Final Report - Corrections Required **Application No. PDZD-26-0017**

Description : PDZ Development Plan for the Paint Mines at Reagan Ranch comprised of 102 single-family attached residential lots on 15.283 acres.

Record Type : PDZ Development Plan

Document Filename : Paint Mines at Reagan Ranch PDZ DP_1st Submittal.pdf

LOT & STREET TYPICALS

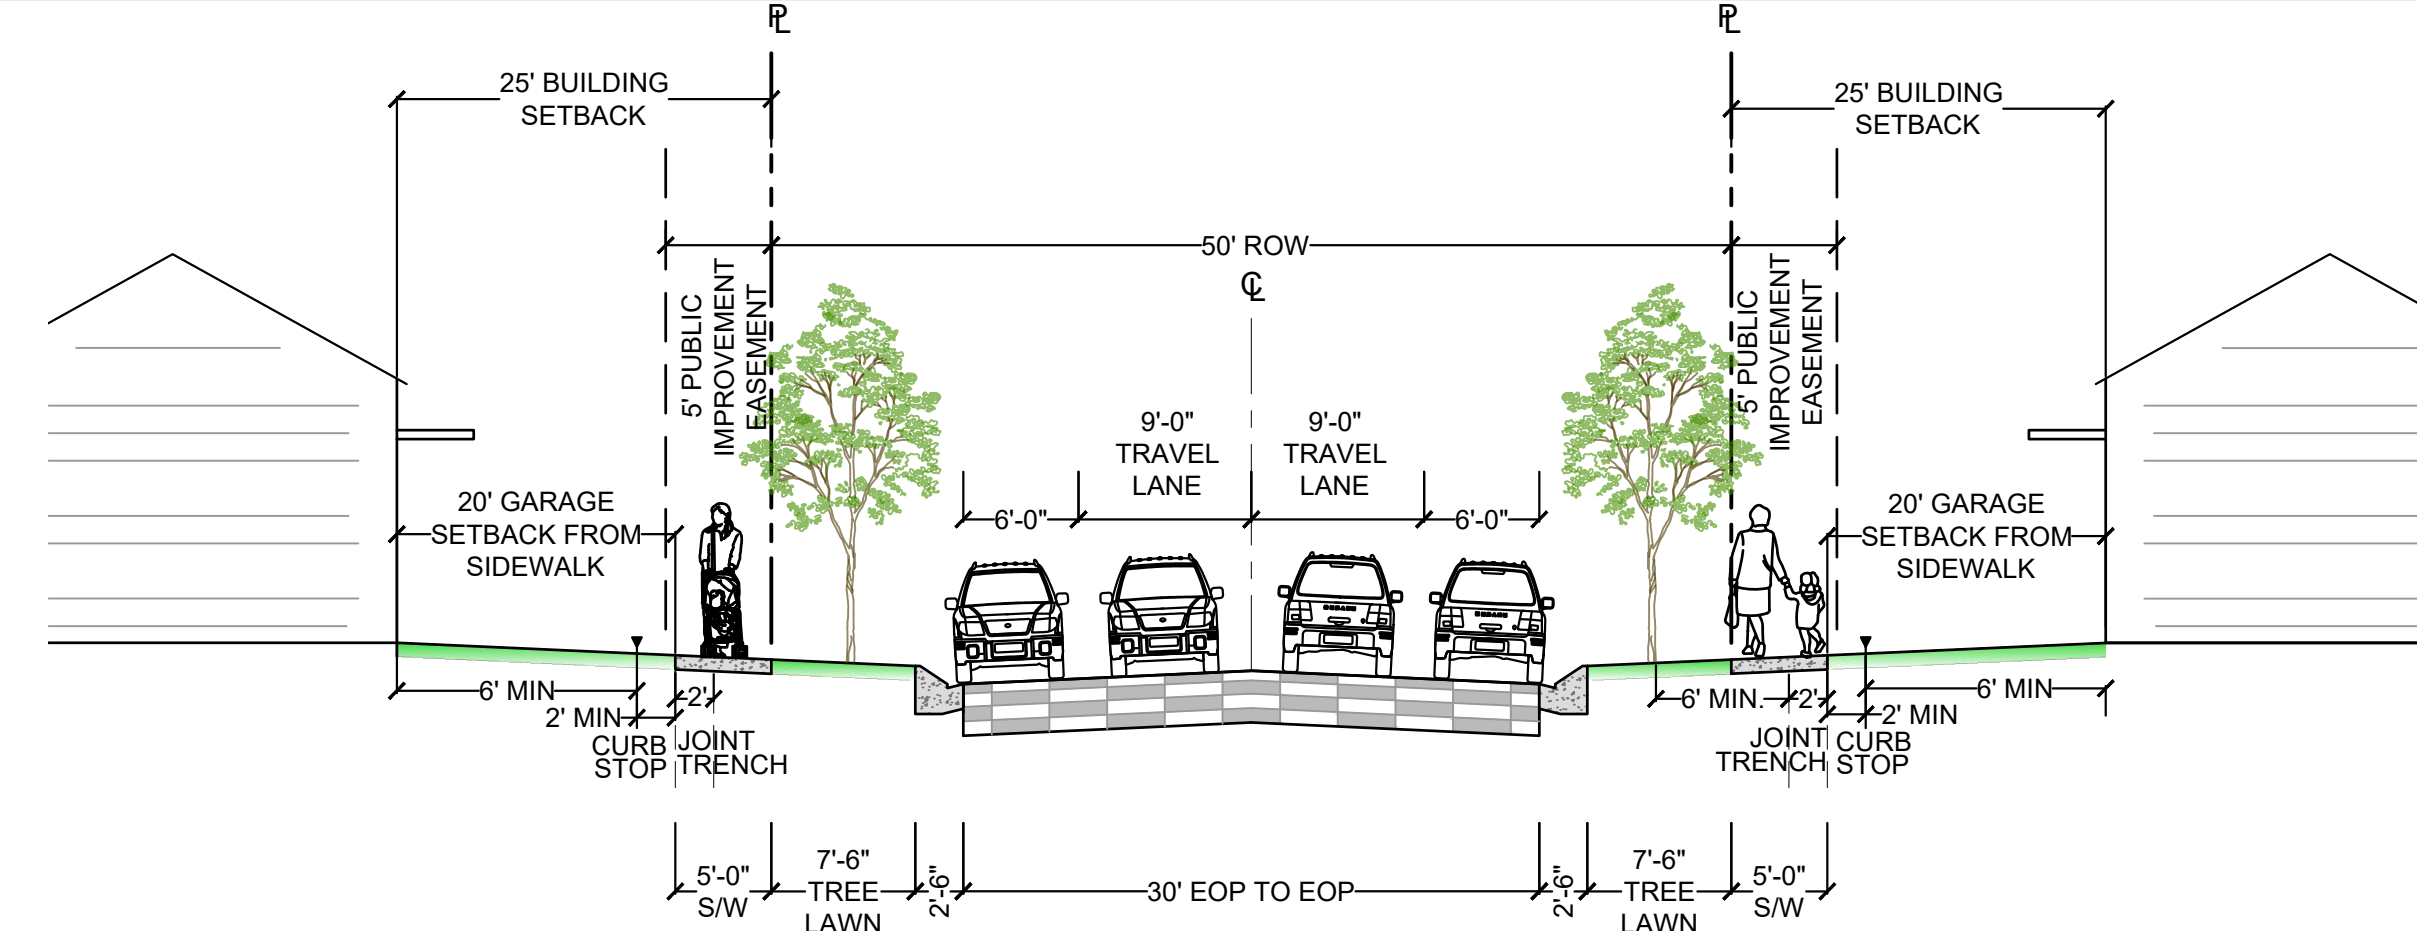
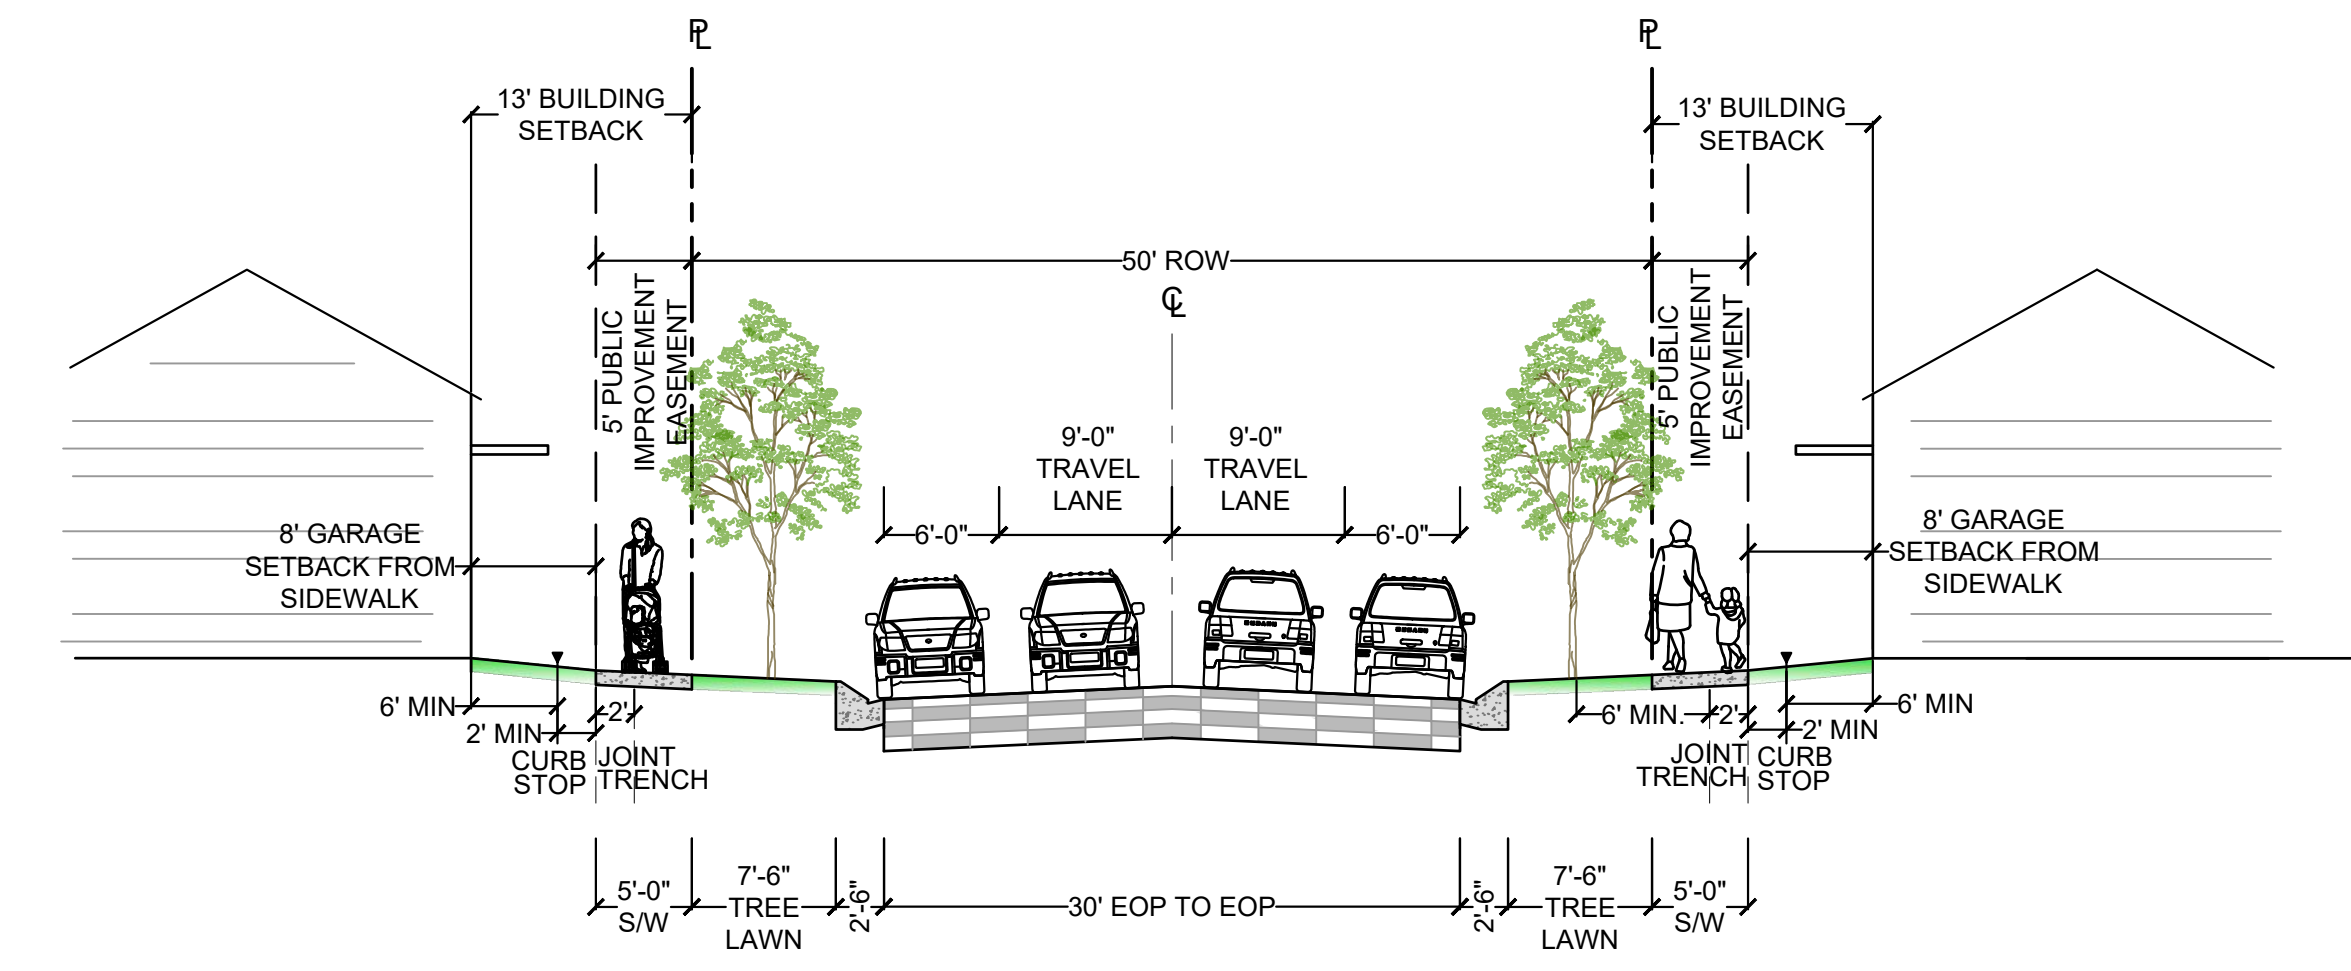
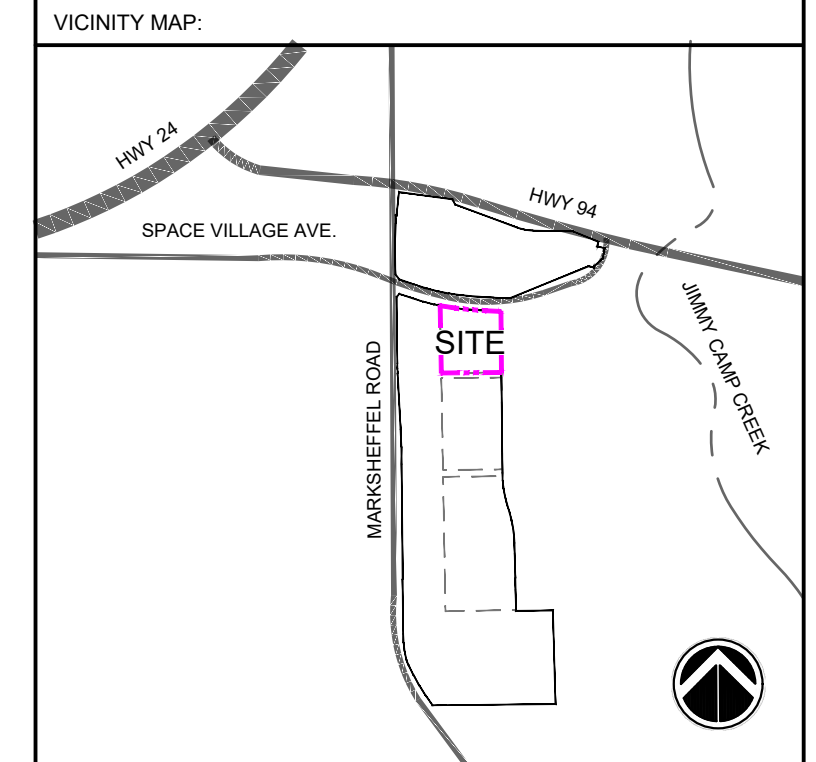
33	1	Patrick Dosch : Col Springs Utilities	Please upload the HGL response form
34	2	Patrick Dosch : Col Springs Utilities	Show or reference A3-10 from the WLESS
35	2	Patrick Dosch : Col Springs Utilities	Show A3-8 (50' ROW) or another approved street cross section from the LESS. Please show all proposed utility configurations in the street cross section
36	2	Patrick Dosch : Col Springs Utilities	Add note "CSU Field Engineer to determine final gas/electric meter, transformer, and service line locations. Contact Field Engineering at 719-668-4985 (Gas) or 719-668-5564 (Electric) with any questions."
37	2	Patrick Dosch : Col Springs Utilities	Add note: " Gas meters must be a minimum of 3-feet from doors, operable windows, or any vents or openings in walls."
38	2	Patrick Dosch : Col Springs Utilities	Gas and electric meter locations need to be shown and labeled on lot typical diagrams. Please also show the curb stop and indicate the horizontal separation from building and sidewalk (trench).
